**Tweed Valley Hospital Multi-Deck Carpark
SSD3 AMENDMENT REGISTER****DCR-SSD3**

We issue herewith the list of changes made on the drawings as sent in the nominate transmissions.

Transmittal Date 16.09.2022

DRAWING TITLE
FACADE TYPES

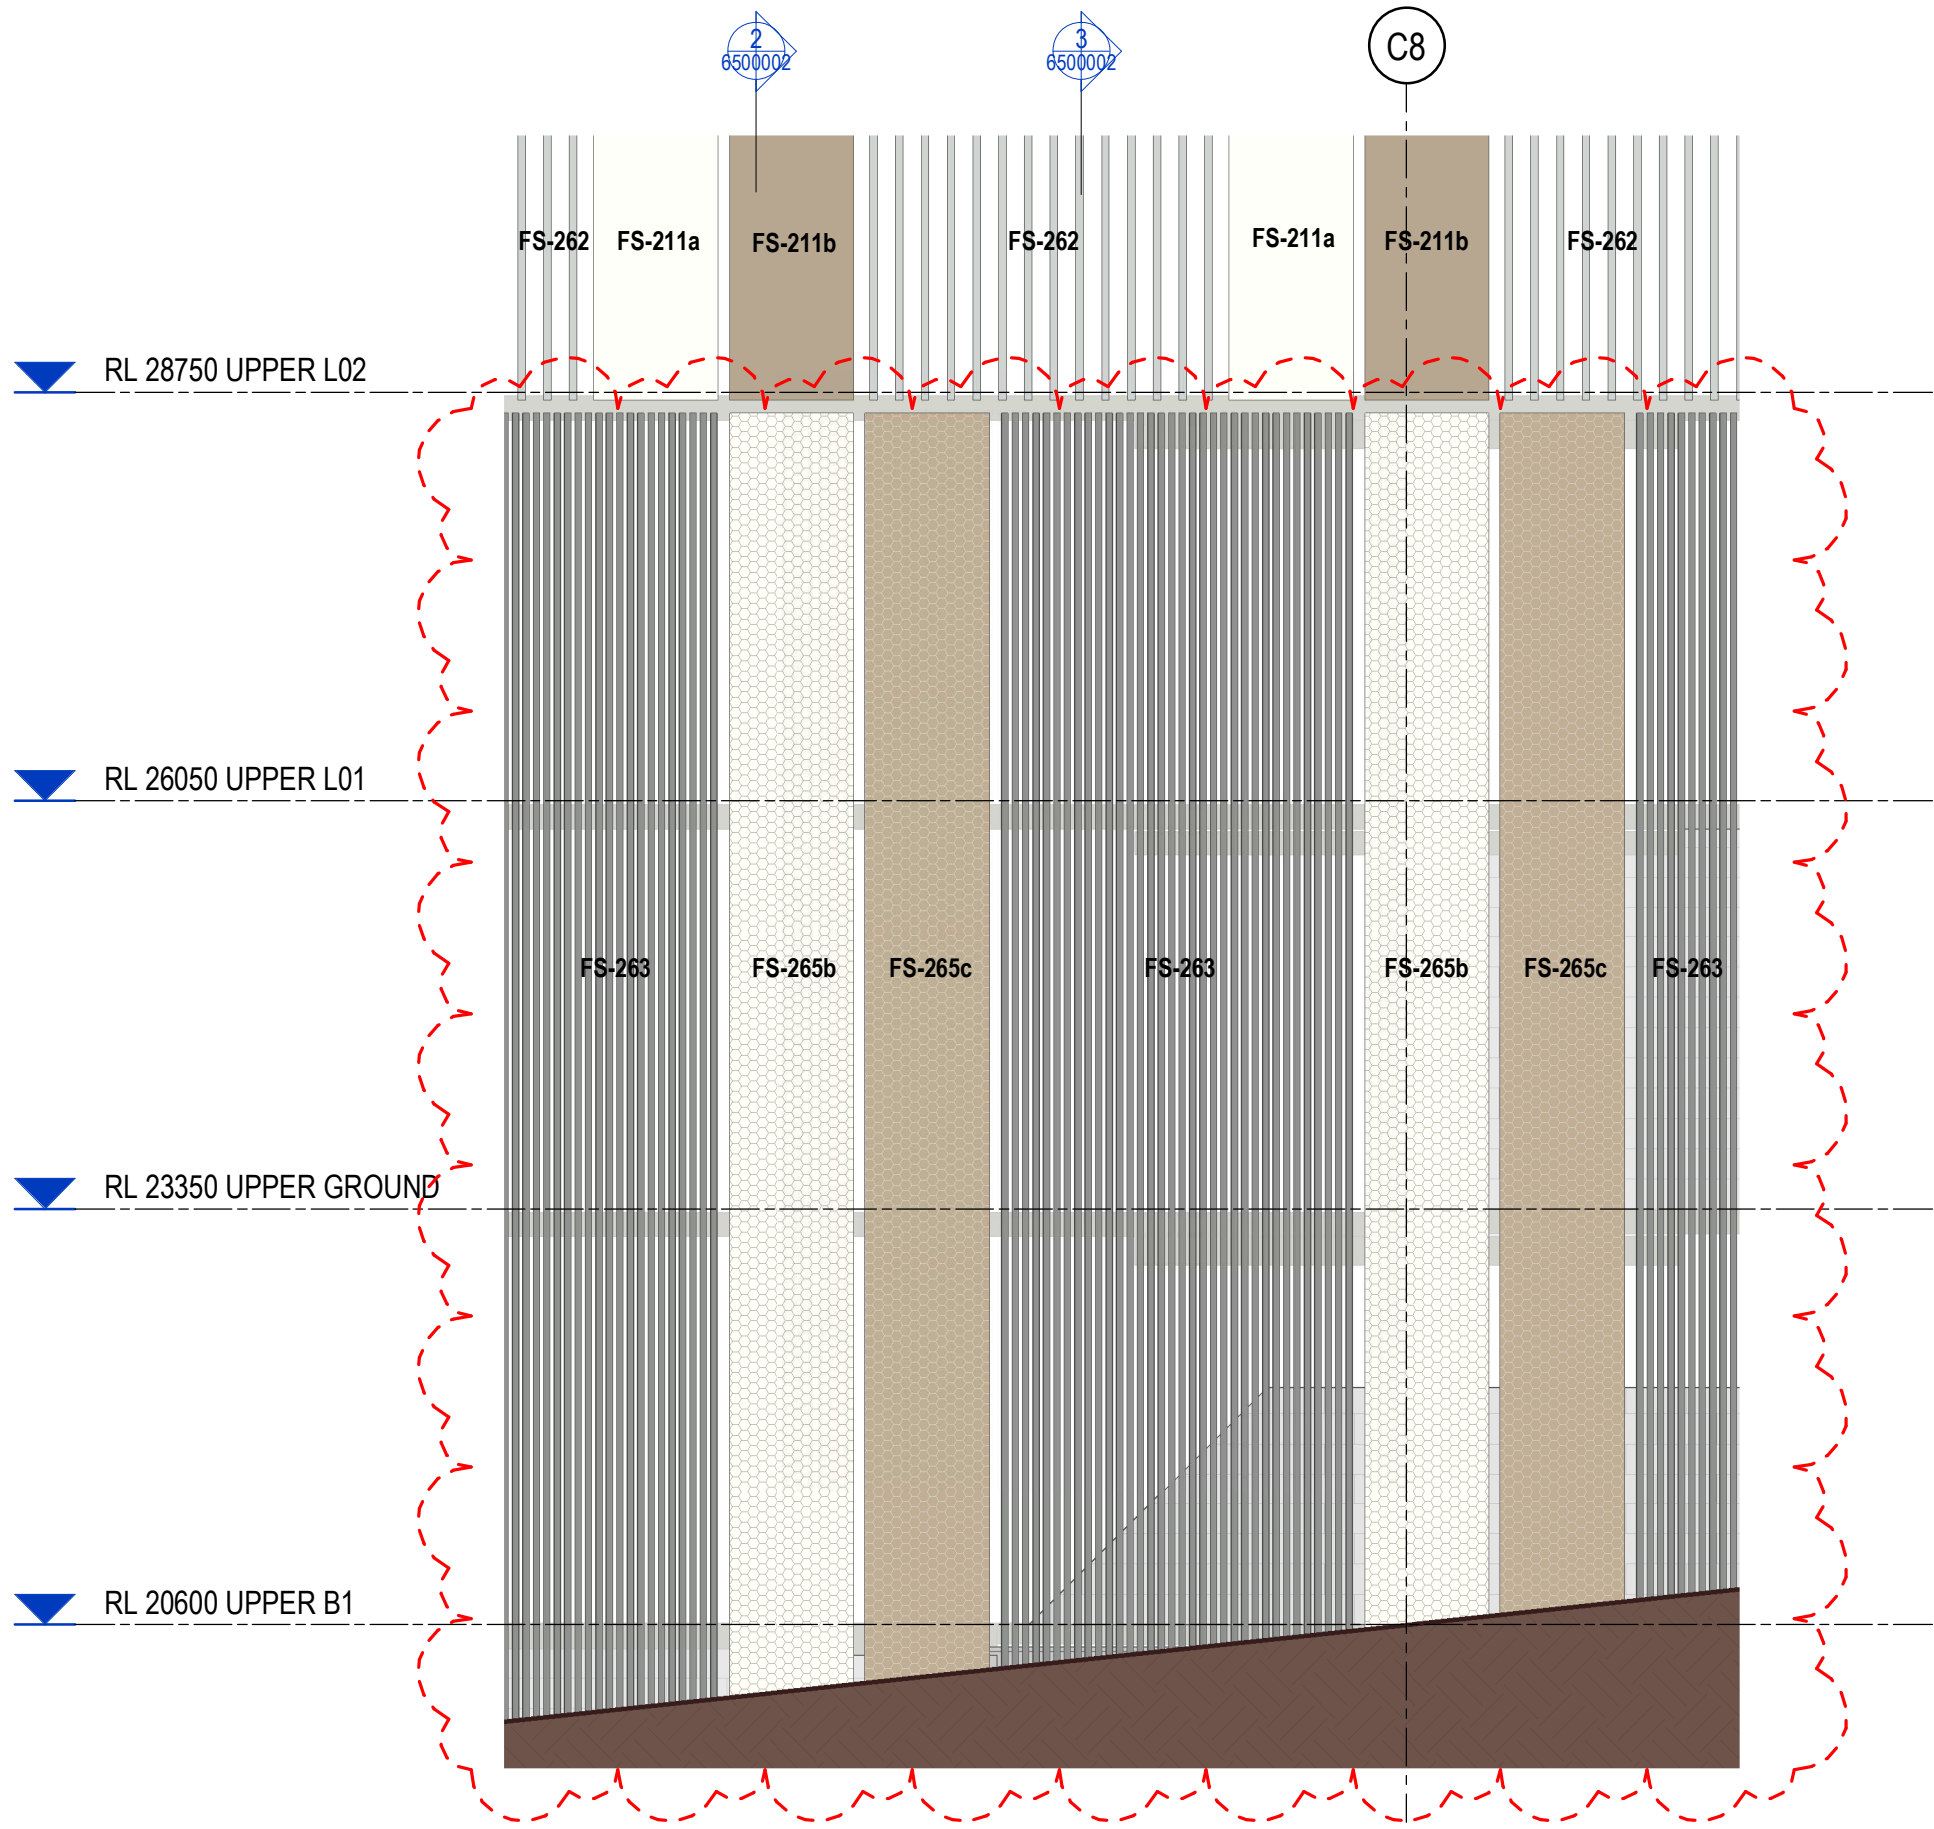
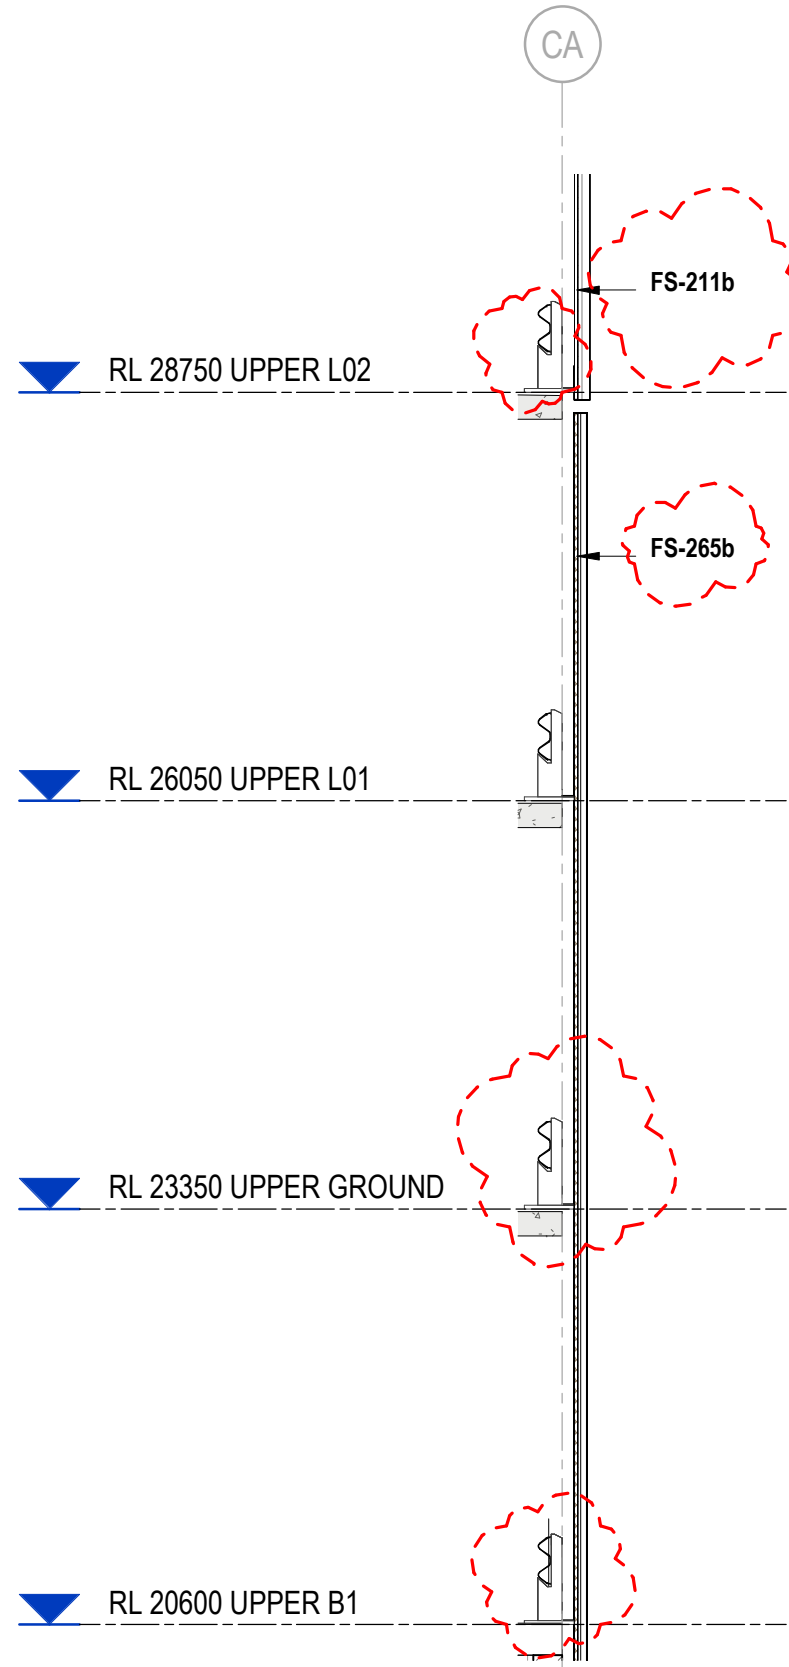
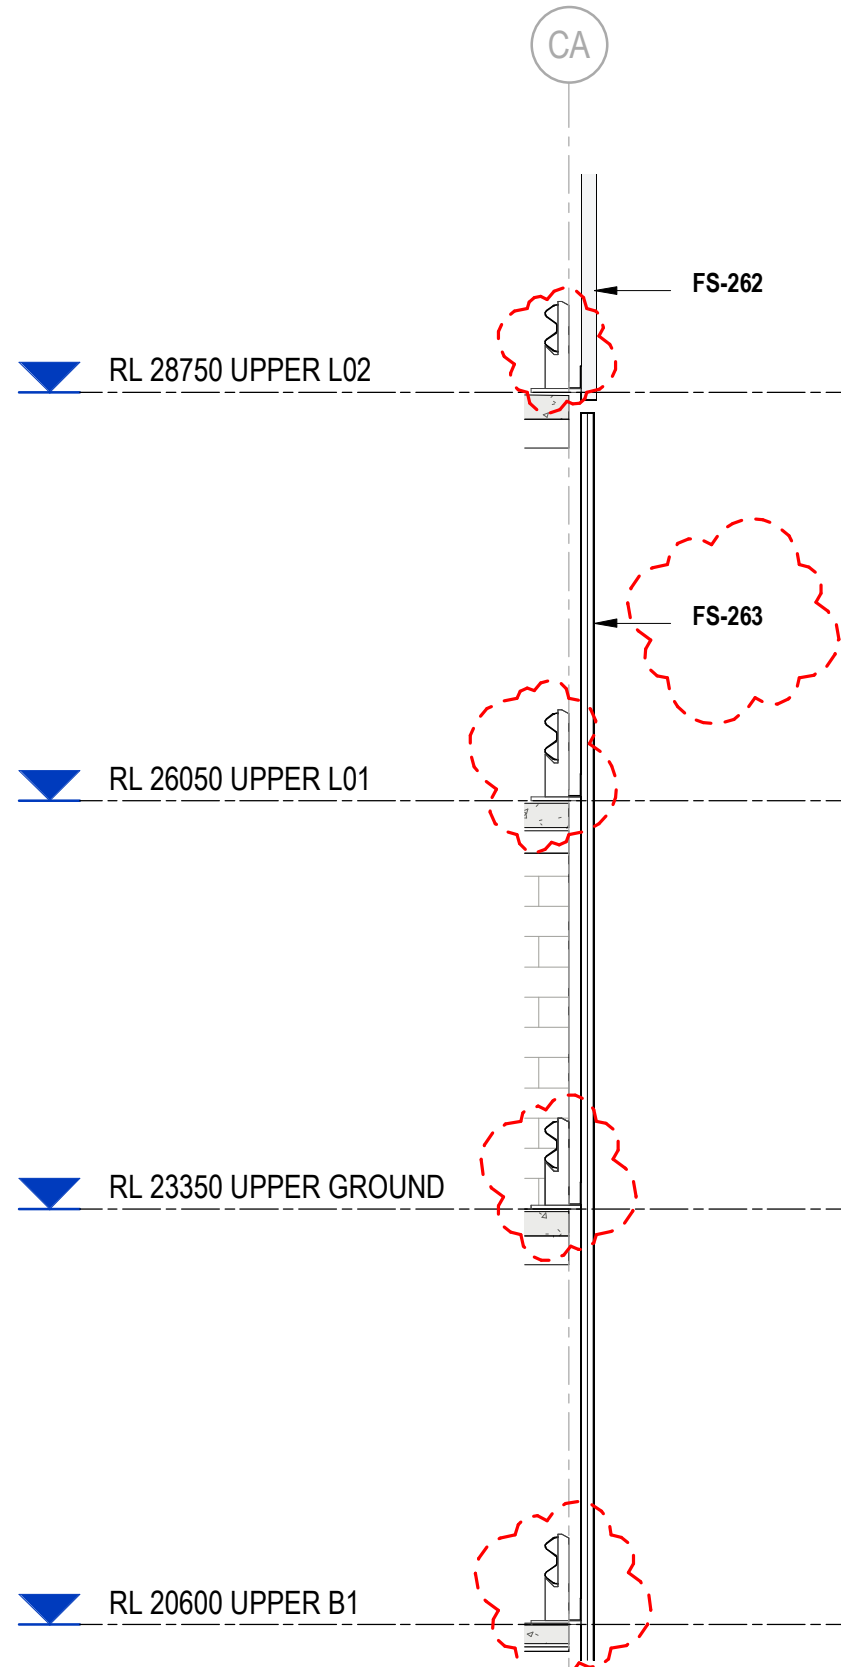
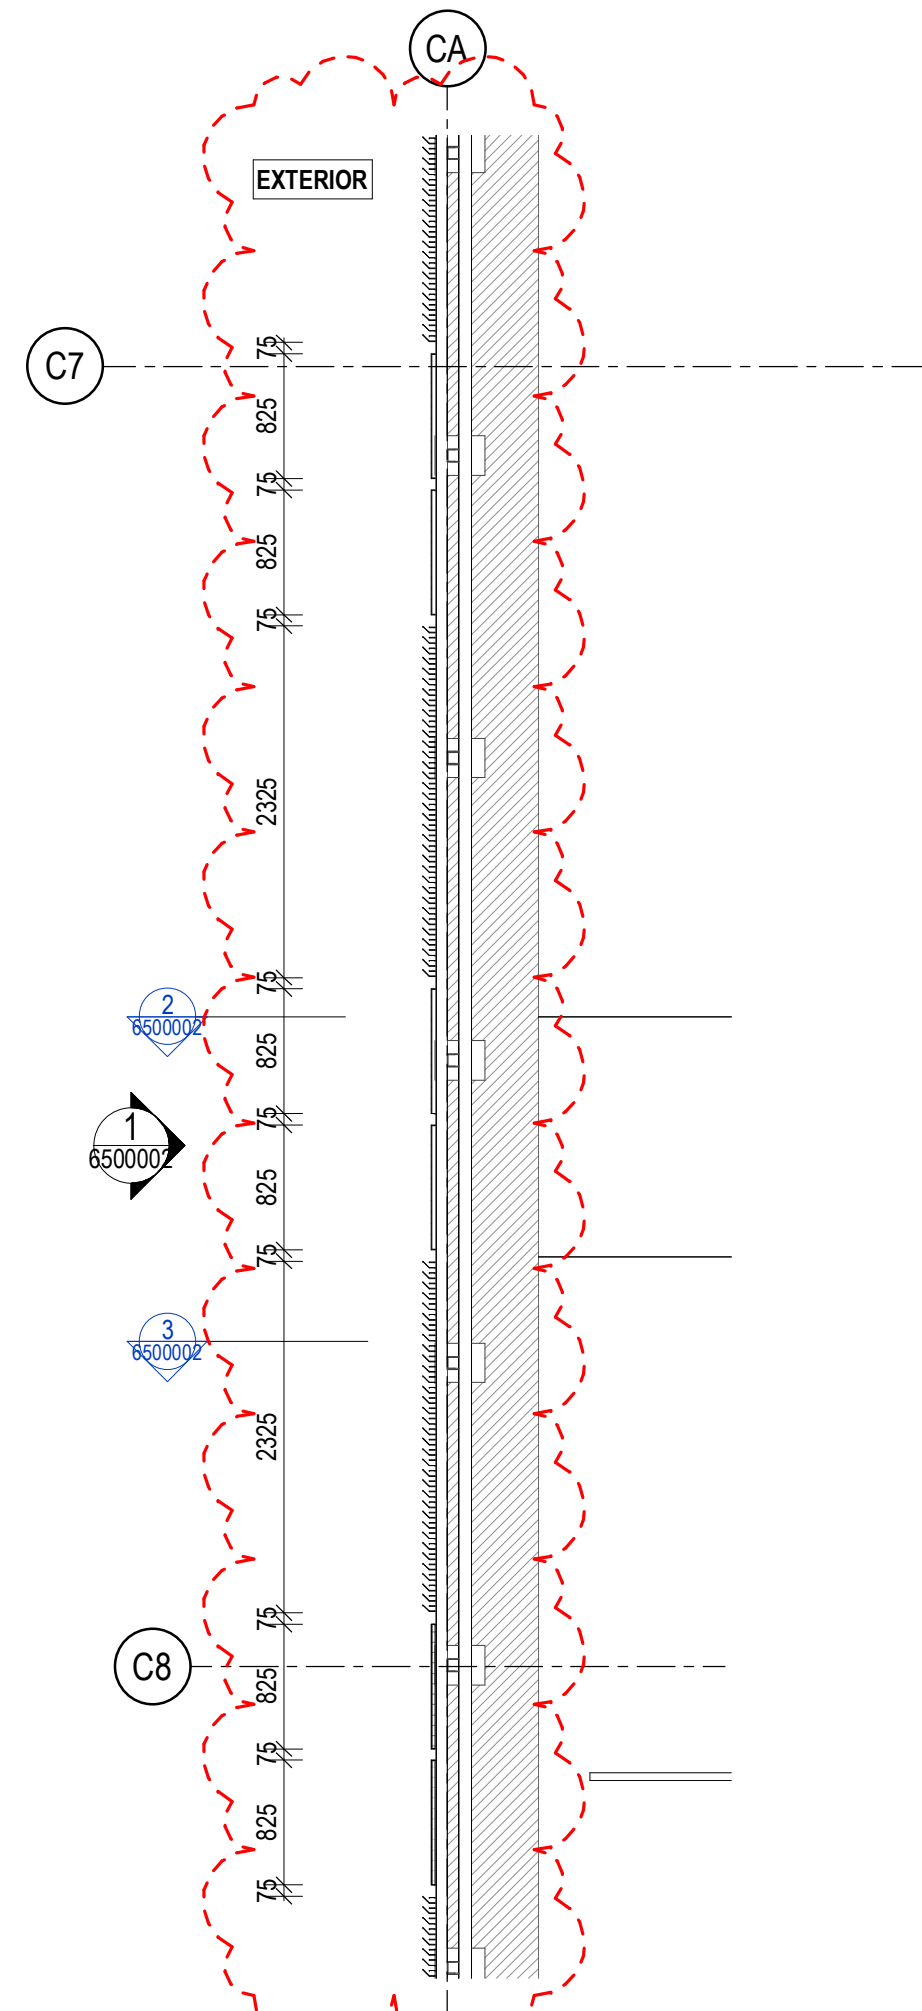
3	Café Tenancy Space added	
			4	Space for Mechanical Exhaust Fans shown in Female	
			5	Operators Office and Fit out adjusted For AS1428.1 compliance	
			6	PWD Amenities Door Relocated	
			7	FHR and Hydrant add to B1 Grid CC as part of design development	
MDD-AR-SKE-MCP-6500001	FAÇADE TYPES	5	1	Façade Types amended to meet requirements of FEBQ and FRNSW - refer to finishes schedule for further detail	
MDD-AR-SKE-MCP-6500002		5	2	Powdercoat colour codes removed, refer to finishes schedule for colour selections	
MDD-AR-SKE-MCP-6500003		5			
MDD-AR-SKE-MCP-6500004		5			
MDD-AR-SCH-SSD2-001	FAÇADE SCREEN SCHEDULE	4	1	Façade Screen type FS-211a perforation pattern amended to meet the requirements of natural ventilation of open deck carpark as stipulated by FRNSW	
			2	Façade Screen type FS-211b perforation pattern amended to meet the requirements of natural ventilation of open deck carpark as stipulated by FRNSW

3	Façade Screen type FS-265b and FS-265c added to meet the requirements of natural ventilation of open deck carpark as stipulated by FRNSW and colour selection enhances and articulates massing and multi-level expression from the Main Hospital Building
